Rezoning Transportation Analysis

Petition Number: 2022-134

Date	Description
01-26-23	First Review (PDM)

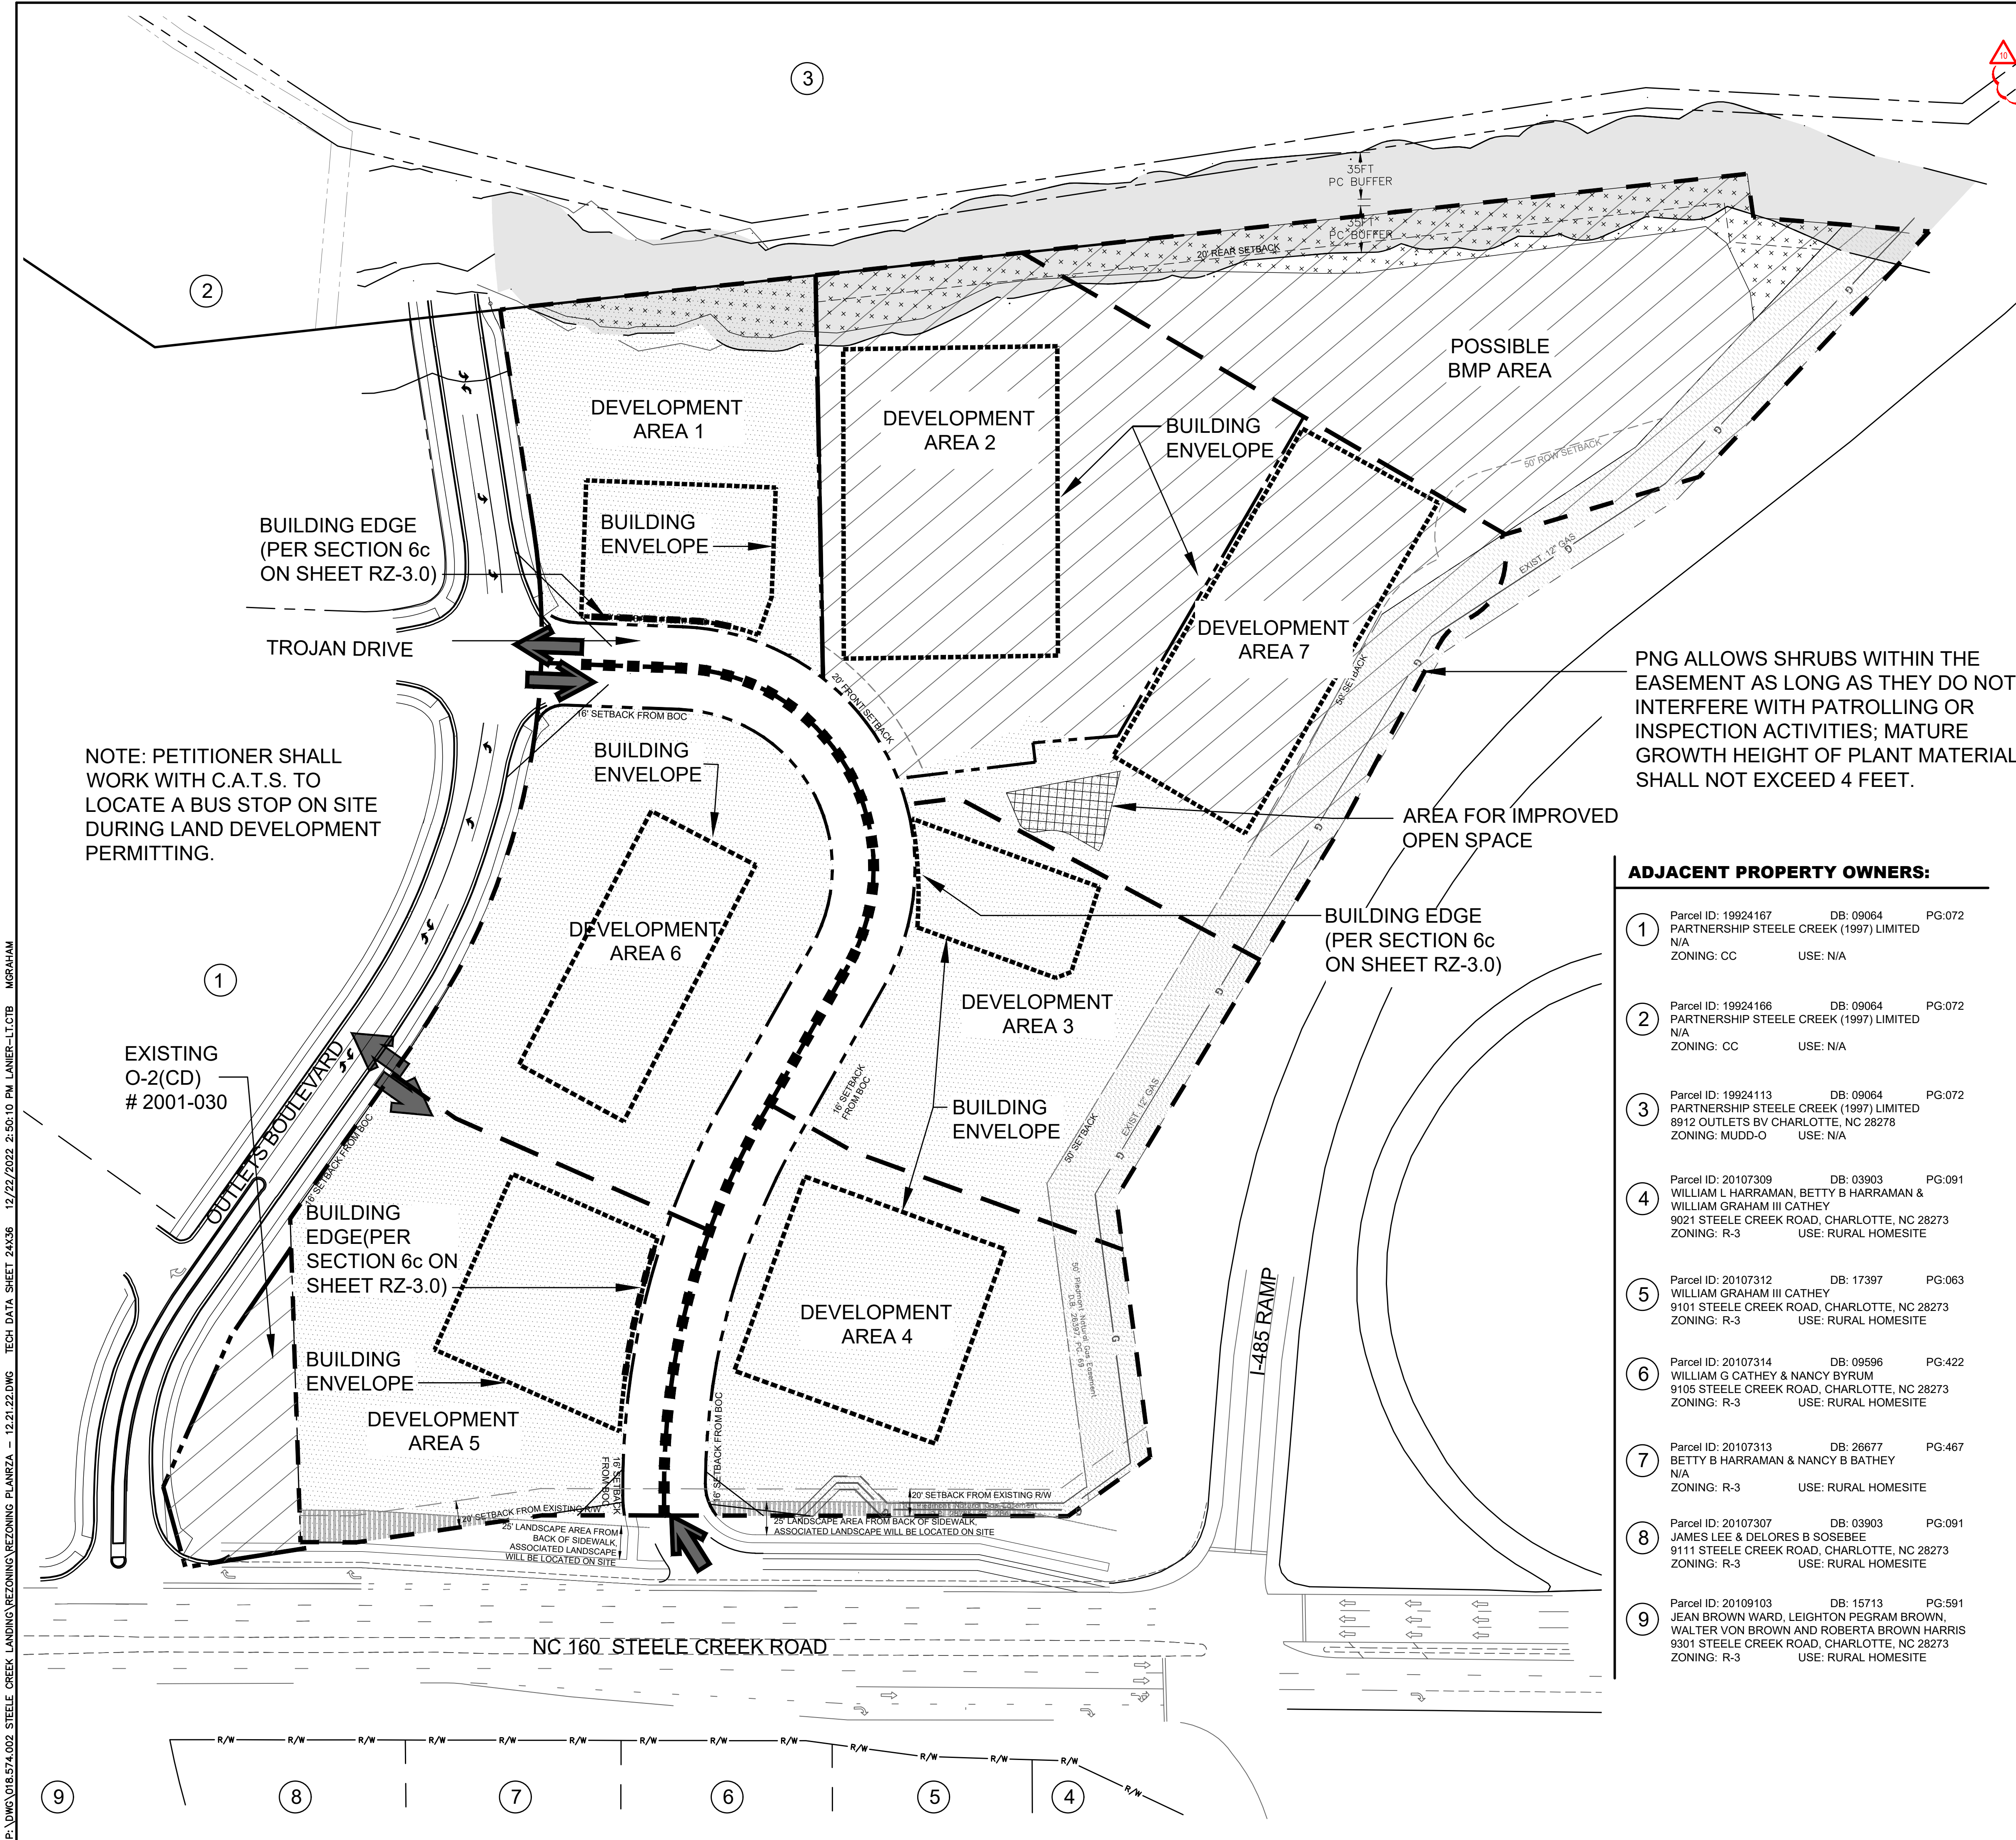
2. Provide documentation from rezoning petition #2017-019 that the \$250,000 financial contribution commitment has been satisfied or add a conditional note committing to the same contribution.
3. Add callout and conditional note for the proposed intersection control to be approved by CDOT during permitting for the below intersection.

4. Add a conditional note specifying "A Right-of-Way Encroachment Agreement is required for the installation of any non-standard item(s) (irrigation systems, decorative concrete pavement, brick pavers, etc.) within a proposed/existing City-maintained street right-of-way by a private individual, group, business, or homeowner's/business association. An encroachment agreement must be

5. Add a conditional note specifying “the Petitioner shall dedicate and convey in fee simple all rights-of-way to the City before the site’s first building certificate of occupancy is issued. CDOT requests rights-of-way set at 2’ behind back of sidewalk where feasible.”
6. Add conditional note specifying “All public roadway improvements will be subject to the standards and criteria of CDOT and NCDOT, as applicable, to the roadway improvements within their respective road system authority. It is understood that such improvements may be undertaken by the Petitioner on its own or in conjunction with other development or roadway projects taking place within the broad south western Mecklenburg area, by way of a private/public partnership effort or other public sector project support.”
